Re: Certification Submittal for Final Building Certificate of Occupancy for
Bill Ramos Storage Bldg., [F-17 / D53A]
4608 McLeod NE
Engineer's Stamp Dated 12/06/06

**RE: BILL RAMOS STORAGE BUILDING @ 4608 McLEOD ROAD N.E.
(F17-D53A)**

Re: 4608 Mcleod Rd NE, Traffic Circulation Layout
Engineer's Stamp dated 03-29-06 (F17-D53A)

Re: Bill Ramos Storage Building, 4608 McLeod Road NE, Grading and Drainage Plan

Sheet Title
GRADING / DRAINAGE PLAN

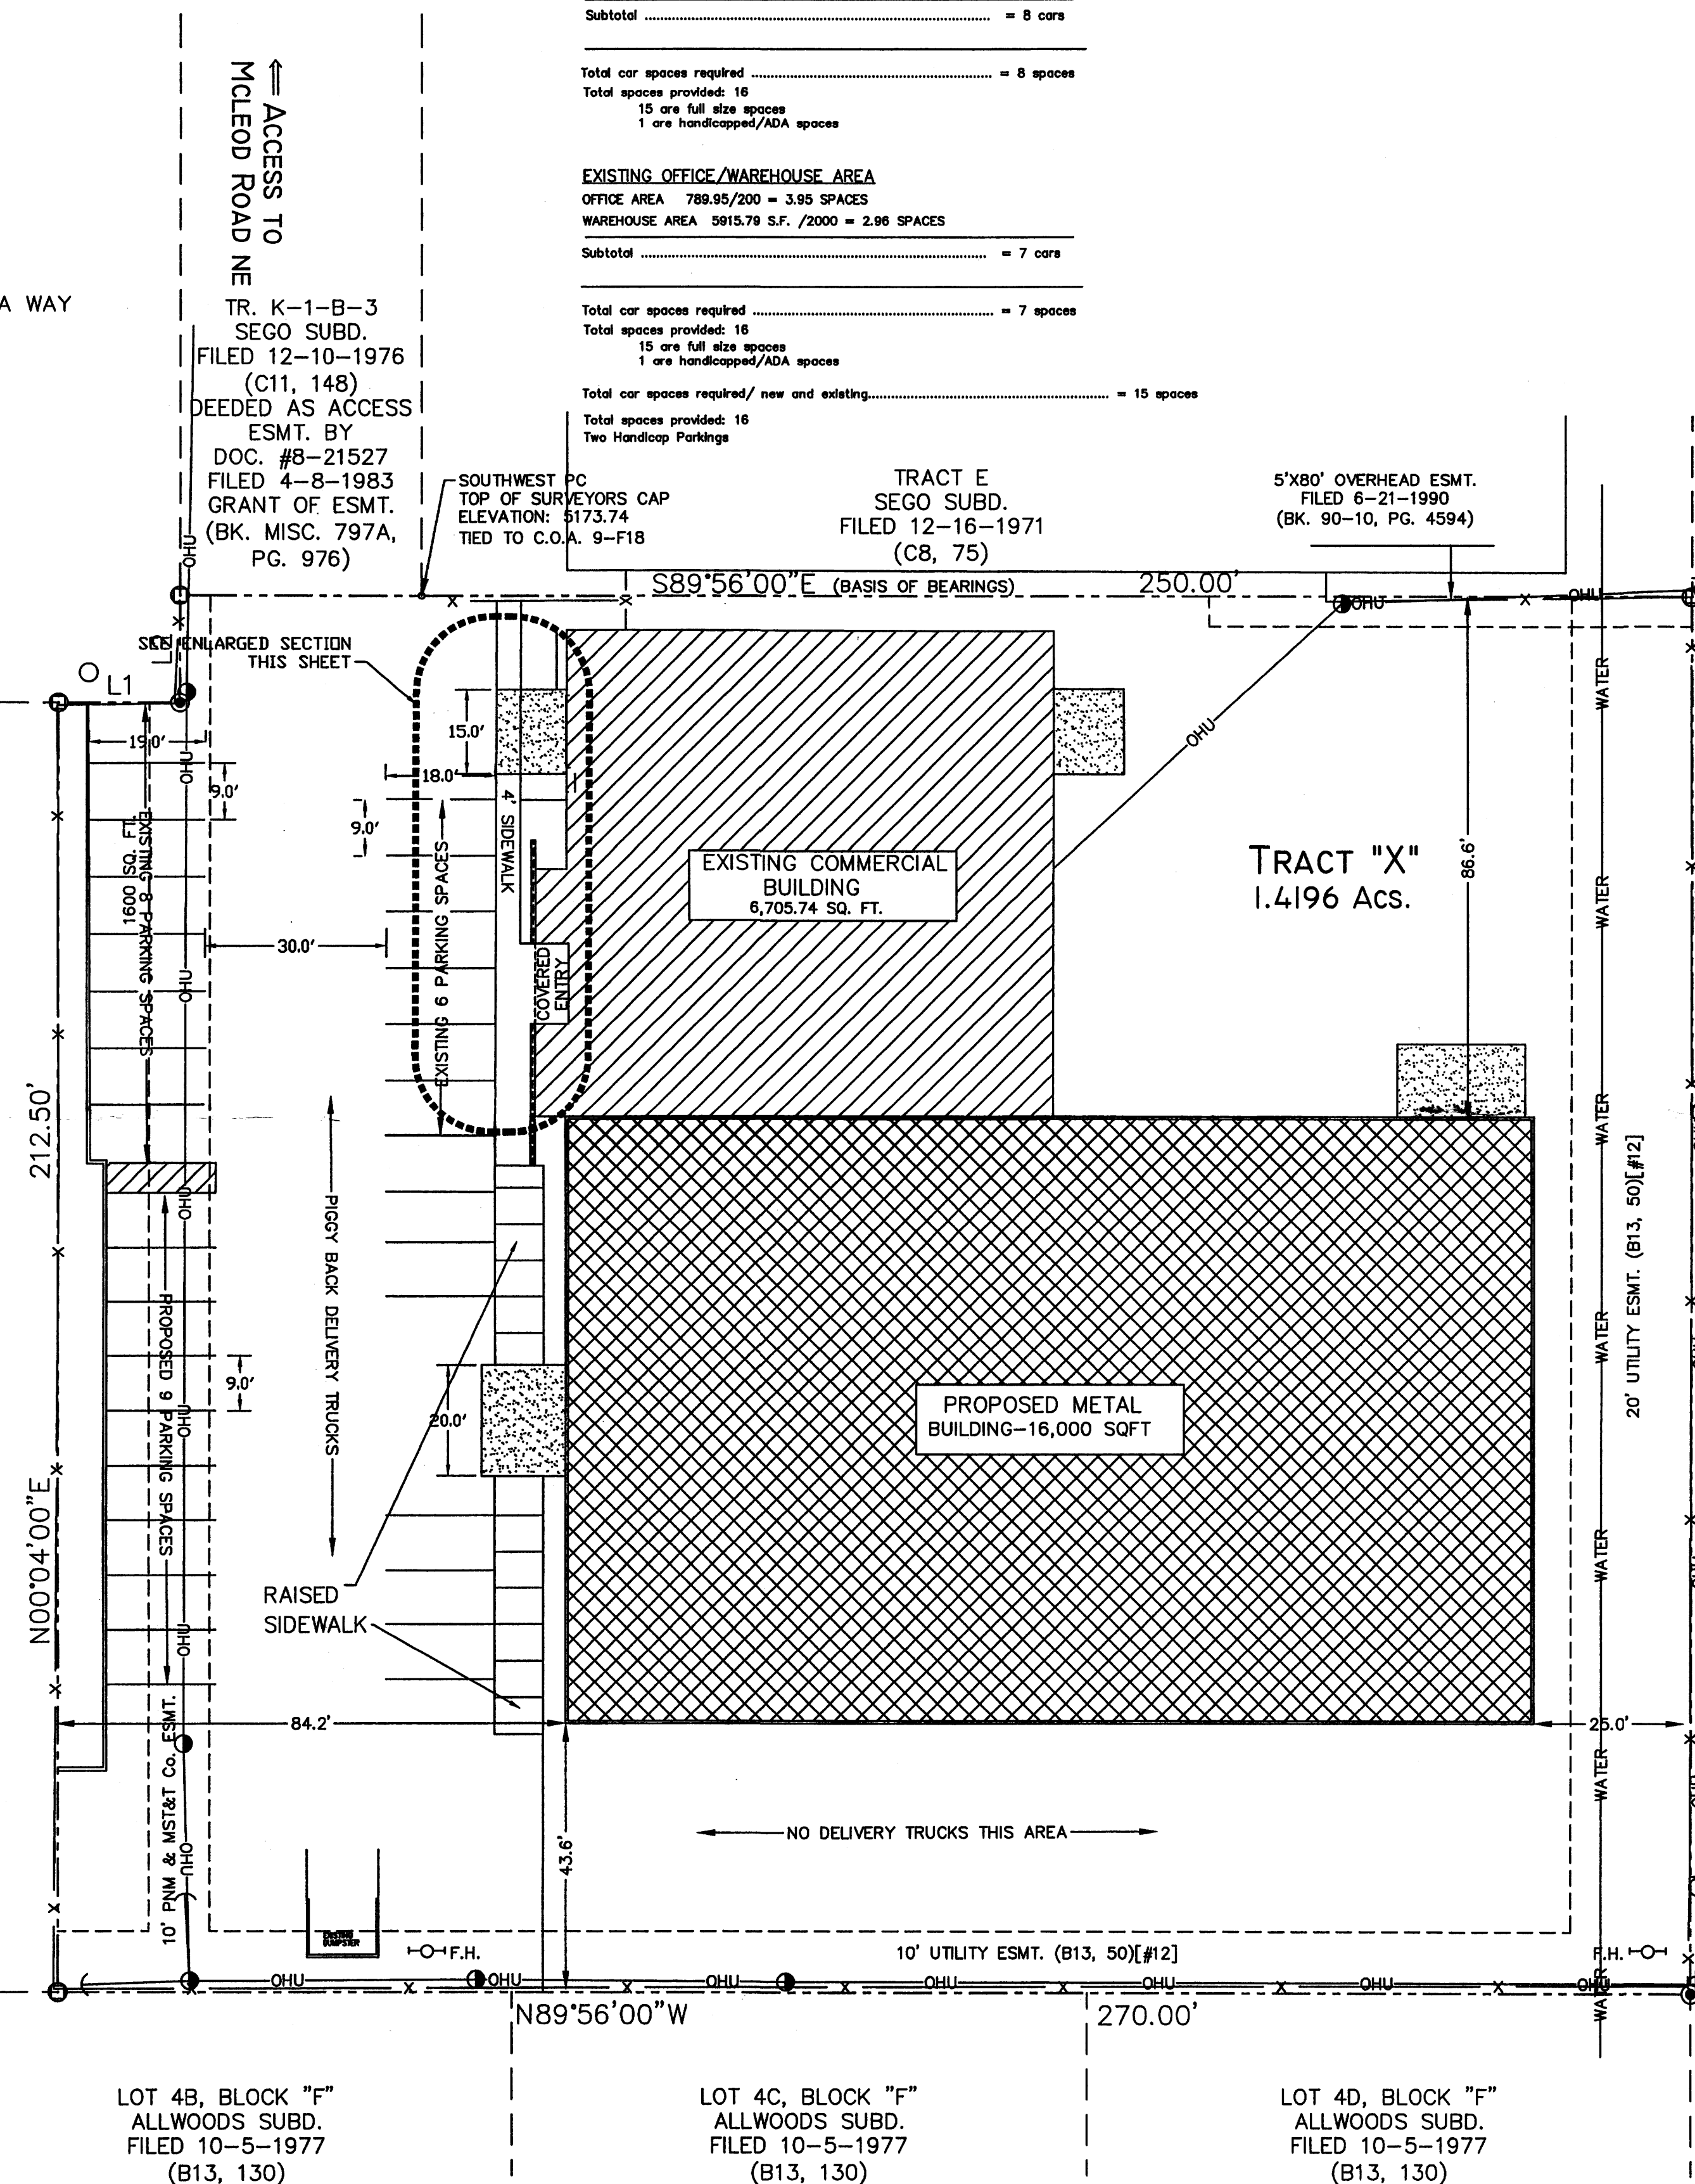
In the future, provide direction of roof flows.

- ✓ 1. The existing layout shown does not match the 2004 arial photo of this area (see attached). Please correct this, and provide information on all existing pavement, buildings, and elevations.

- ✓ 2. Enlarge the smaller text. A minimum of 0.1" is required.
- ✓ 3. The existing finished floor elevation shown does not match the finished floor elevation defined in the previously approved plan (approved 11/1989).

- ✓ 4. Check the math for the proposed peak discharge. When I calculate this value, I get 6.29 cfs, not 5.93 cfs.
- ✓ 5. The existing areas shown in the calculations do not total the site area. Based on my calculations, the following percentages apply:

- Land Treatment Type A – 0%
 - Land Treatment Type B – 2%
 - Land Treatment Type C – 69%
 - Land Treatment Type D – 29%Based on these percentages, the existing flow would be approximately 5.08 cfs.

- ✓ 6. Is the area providing access to McLeod Road a public roadway or a cross lot access easement? Does this area have a cross lot drainage easement as well?

1. The existing layout shown does not match the 2004 arial photo of this area (see attached). Please correct this, and provide information on all existing pavement, Buildings, and elevations. *Attached you will find a copy of an Alta survey done in July of 2005 and a copy of the topo prepared by Advanced Engineering in February 2006, both indicating that there was no building to the south of the existing building. What I have computed is what was on the Alta and survey provided to me. I did compute a new spread sheet that includes the removed building for your information.*

2. Enlarge the smaller text. A minimum of 0.1" is required. *The smaller text has been increased on the Plan Drawing.*
3. The existing finish floor elevation shown does not match the finished floor elevation defined in the previously approved plan (approved 11/1989). *The existing finish floor shown on the 1989 plan is 5176.06 compared to 5175.99 which 0.07' difference, this could be due to the accuracy of the instrument used for the topo. I have attached a copy of the topo prepared by Advanced Engineering.*

4. Check the math for the proposed peak discharge. When I calculate this value, I get 6.29 cfs, not 5.93 cfs. *The calculations have been revised to indicate 6.29 cfs and not 5.93 cfs. My spreadsheet had an incorrect factor.*

Based on these percentages, the existing flow would be approximately be 5.08 cfs. *As I indicated on comment #1, both the Alta Survey and the area topo do not include the building to the south. I have included the building in my new calculations to increase the historical or existing flow to 5.20 cfs, which gives me a smaller increase in flow rate.*

- ✓ 6. Is the area providing access to Mcleod Road a public roadway or a cross lot access easement? *The area from the North property line to Mcleod Road is an access easement by deed as shown on the Alta Survey. Does this area have a cross lot drainage easement as well? The access easement also serves as access, utility and drainage for all the surrounding parcels (Tract N, Tract E, Tract X, and Tract B and B-1).*

TRAFFIC CIRCULATION PLAN

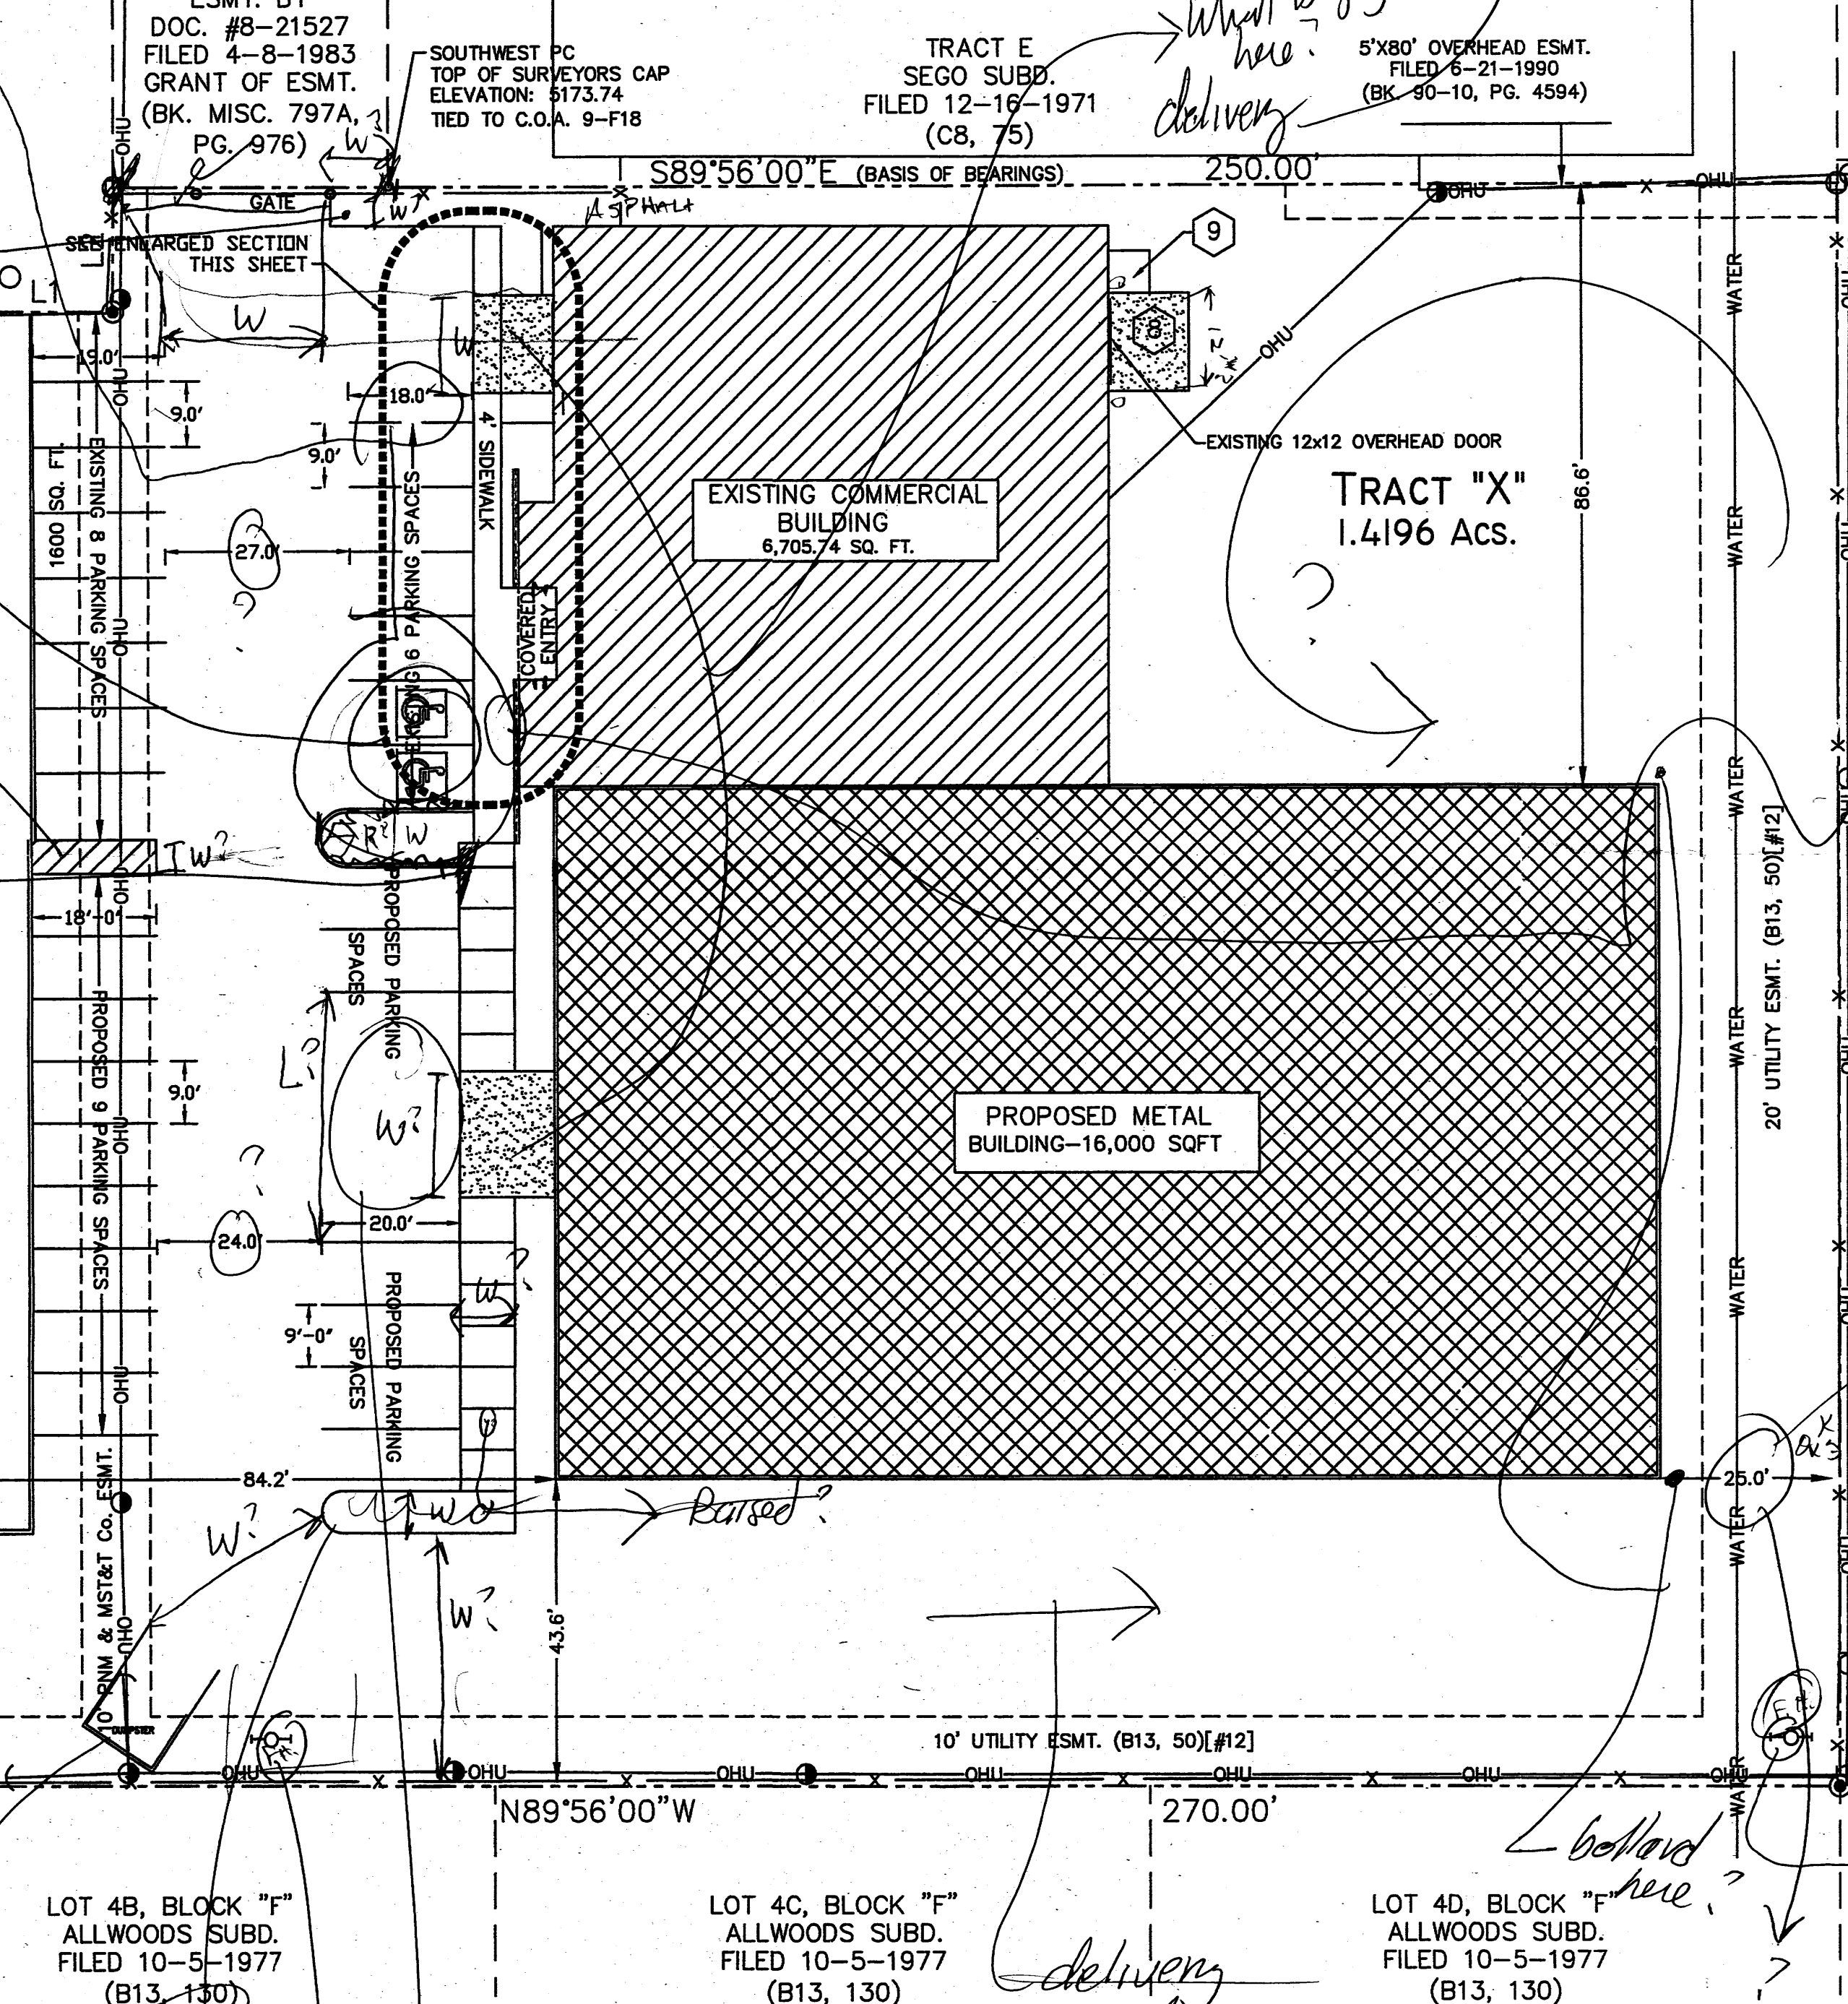
1. Please, refer to all appropriate City Standards; the drawing number should be included in this reference.
2. Provide and label all curves.
3. See attached plan for additional comments that need to be addressed.

STD. SPECS,
LABEL ALL CURVES

~~8' SW / OR~~

? \Leftrightarrow 8' SW w/ 20' w/ PRK Bumper.

SW. WIDTH @ West SIDE PROPOSED Building

PARKING Calculations Do they need to reflect
all parking provided / or just proposed?

SW. SHOW TRANSITION

WIDTH OF EASEMENT (ACCESS.)

- How DOES EASEMENT TIE INTO MCLEOD § is this easement wide enough for
- TURN AROUND.
- IS A DRIVEWAY PAD AVAILABLE FOR EASEMENT.
